# Rezoning Transportation Analysis

Petition Number: 2022-189

Date	Description
3-22-23	First Review (JP)

SITE PLAN

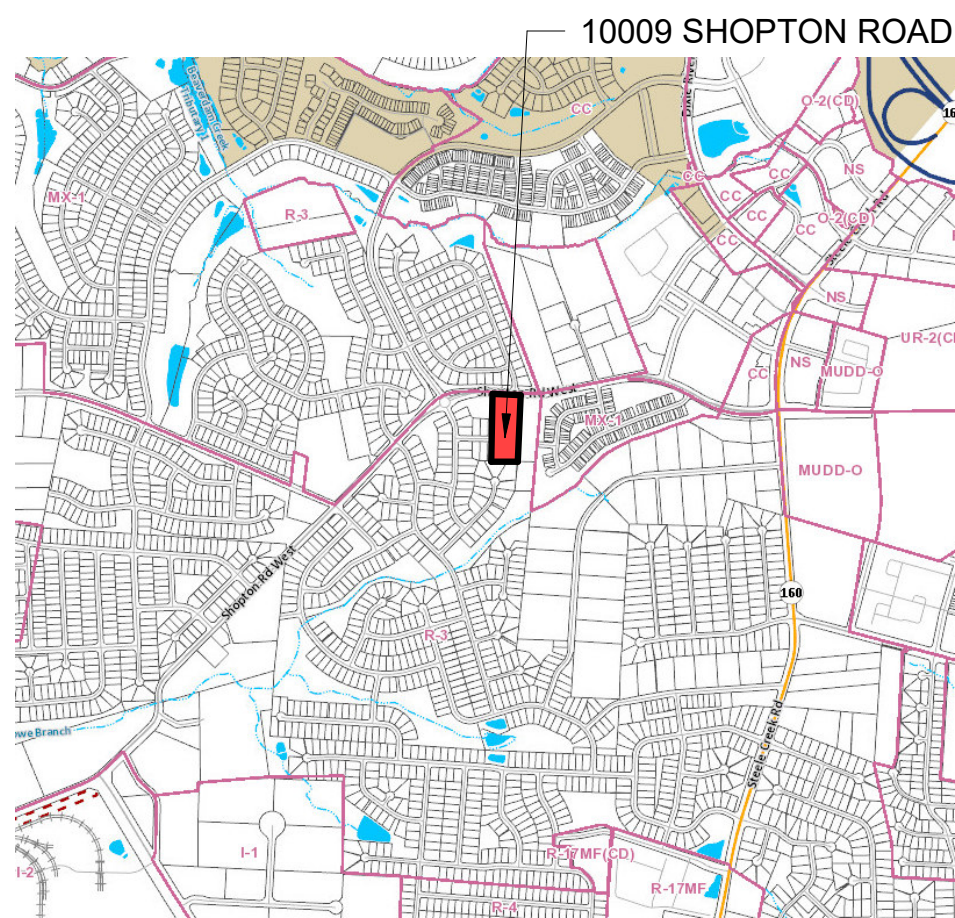
- a. **Shopton Road West:** Location of the future curb and gutter to be installed at 30 feet from roadway centerline to accommodate the Charlotte Streets Map roadway typical section of a four plus lane avenue with shared use path. The existing curb line is not required to be relocated with this petition.

Label and dimension the curb and gutter from the centerline for each road on the site plan.

3. Revise site plan and conditional note(s) to commit to dedicate 50' right-of-way from the road centerline on Shopton Road West. The site plan shall label and dimension the right-of-way from the road centerline.
4. Revise site plan to match the site entrance with the existing Kirkwynd Commons Drive.

5. Revise site plan to show proposed private street (Kirkwynd Commons Drive extension) as a public street (U-02 local residential medium street) with the necessary public ROW.

6. Revise site plan and conditional note(s) to commit to construct an 8-foot planting strip, and 12-foot multi-use path on Shopton Road West per Chapter 19. The site plan shall label and dimension both items from the back of curb and gutter or edge of pavement. The multi-use path and planting strip shall be located behind the future back of curb.

7. Revise site plan and conditional note(s) to commit to construct bicycle facilities by installing a 12' multi-use path to meet the Council-adopted Charlotte BIKES Policy. Multi-use paths maintained by the City shall meet ADA/PROWAG requirements.

12. Revise site plan and conditional note to permanently remove existing pedestrian crossing. This includes the removal of the pedestrian refuge island, 2 ADA ramps, and the marked crosswalk. Revise conditional notes.

Existing pedestrian crossing to be removed permanently, this includes the pedestrian refuge island, 2 ADA ramps, and the marked crosswalk.

13. Revise site plan and conditional note to install valley curb on Newtonmore Drive. Verify that the proposed cross-section matches the existing Newtonmore Drive. Revise conditional notes.

This needs to match the cross-section for the existing Newtonmore Drive. Install valley curb, not 1'-6".
